PROJECT: Strategic Housing Development

REPORT: Statement of Response to An Bord Pleanála's Notice of Pre-Application Consultation Opinion Ref.: ABP-312246-21

CLIENTS: Arnub Ltd. & Aspect Homes (ADC) Ltd

DATE: September 2022

Drawing file: Drawings / D2101.S.13 Site Layout - Open Space.pdf

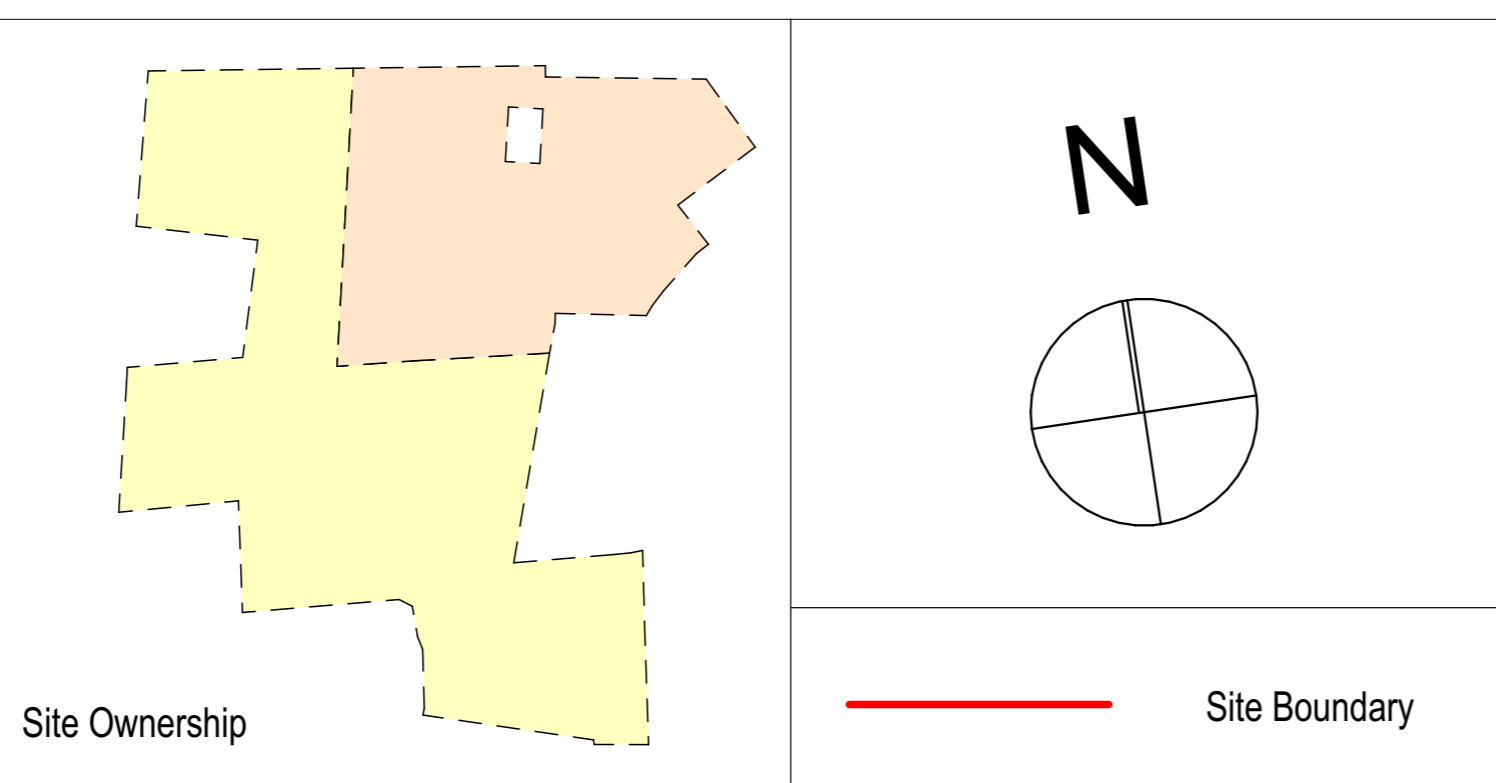
(c) Provide further justification for the design and layout of all public open space areas. This further justification should address, inter alia, the location of the public open space, the need for passive surveillance and appropriate functionality of space.

Public open spaces is provided throughout the development (c.2.88Ha) and is interlinked to create a “necklace / linear park” of space that is useable, accessible, caters for varying forms of recreation and play and contributes to the green infrastructure network. The landscape concept for the linear park is based upon the idea of combined openness and enclosure of a natural landscape/parkland setting. Working in harmony to create an ever-hanging linear park which acts as a green spine to the overall scheme that offers breakout areas for a multiple of different recreational uses. These would include large open areas of grass for kickabout spaces; play areas for all aged groups dotted throughout the open spaces to ensure good proximity for the entire development; plaza spaces to offer gathering and outdoor seating positioned to maximize sunny positions; good circulation of paths for walking, cycling, dog walking and running. The linear park will create areas for native and natural planting to enhance local biodiversity.

The submitted landscape design report clearly outlines the aims and objectives for the proposed landscape design, green infrastructure plan, details of the landscaping for the proposed plaza area, and linear park which will provide an attractive setting for play / walking / running / cycling / skating / external exercise equipment. The attenuation basin will be incorporated into a natural play area.

All open spaces are passively supervised by buildings and dwellings facing directly onto same, which is evident from the site layout plan and plans of the proposed dwellings.
